Our Ref: 24/00909/HFUL
Your Ref: Bike shed

**Cambridge City Council
Application for Planning Permission**

Proposal: Erection of a bin and bike store with a sedum roof to the front elevation.

Site address: 38 Frenchs Road Cambridge Cambridgeshire CB4 3LA

Bin Store

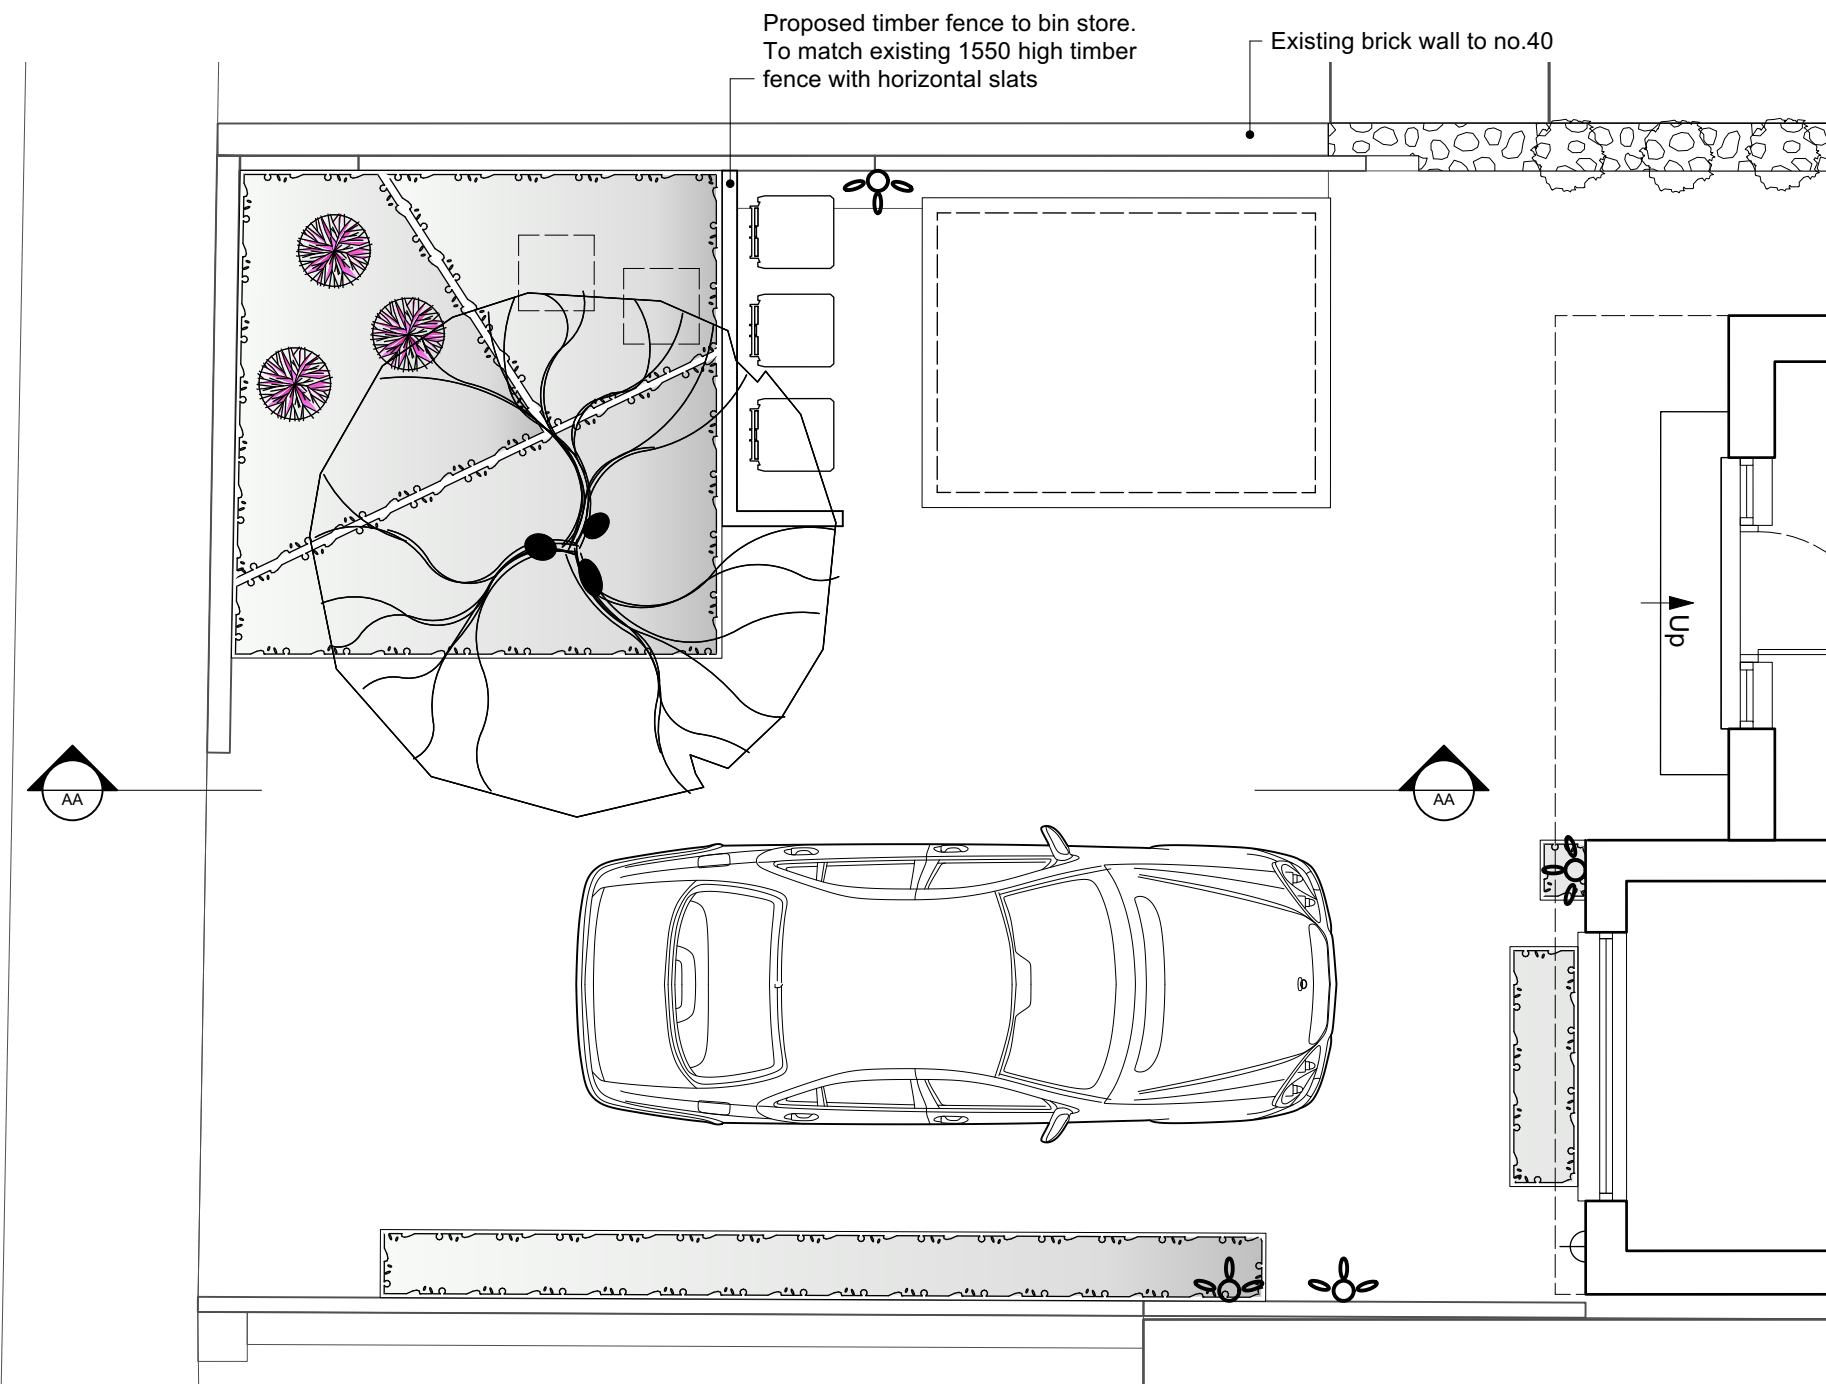
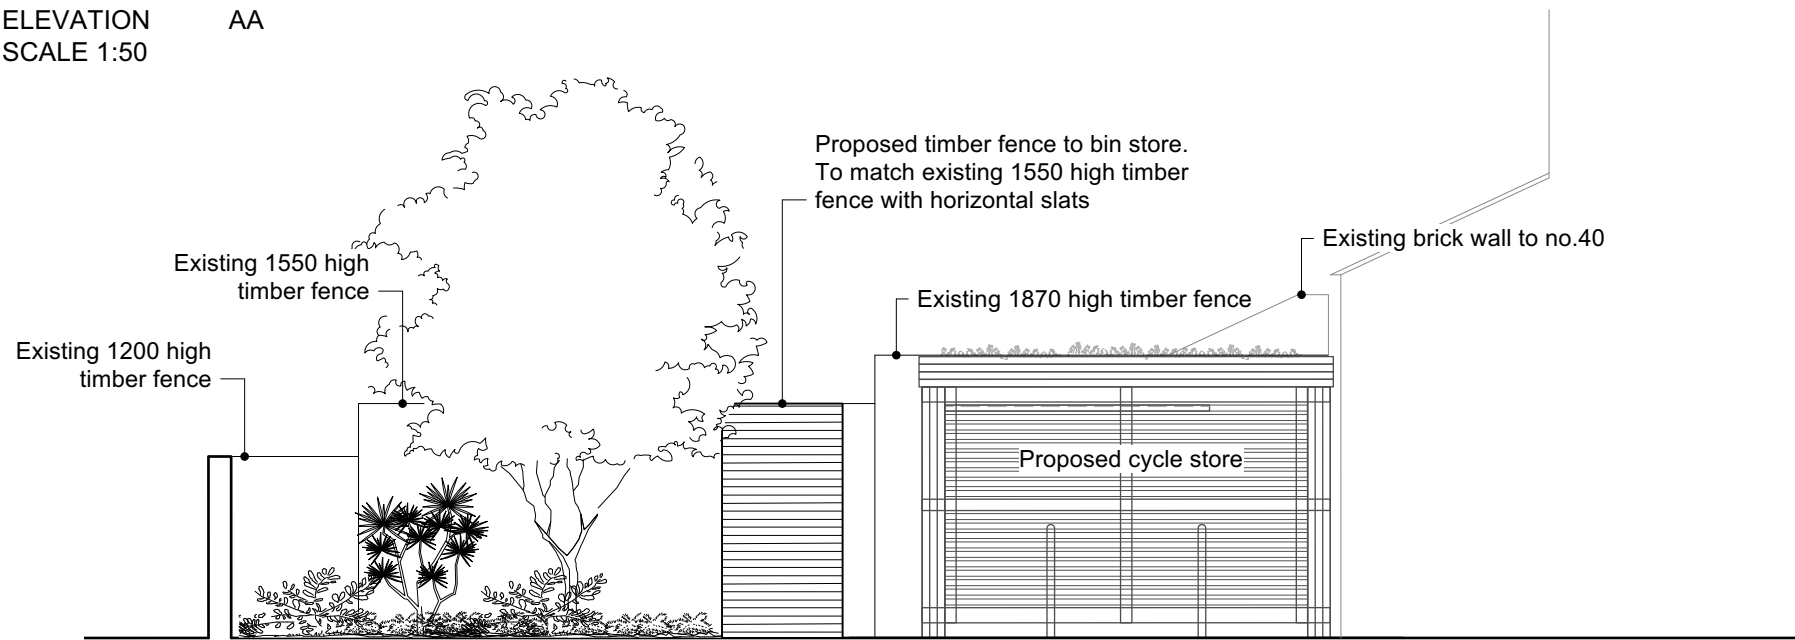
1. Please add a scale bar to drawing no 352 bin store.
2. Please add a scale bar or measurements to the street elevation
3. Please agree to the revised description.
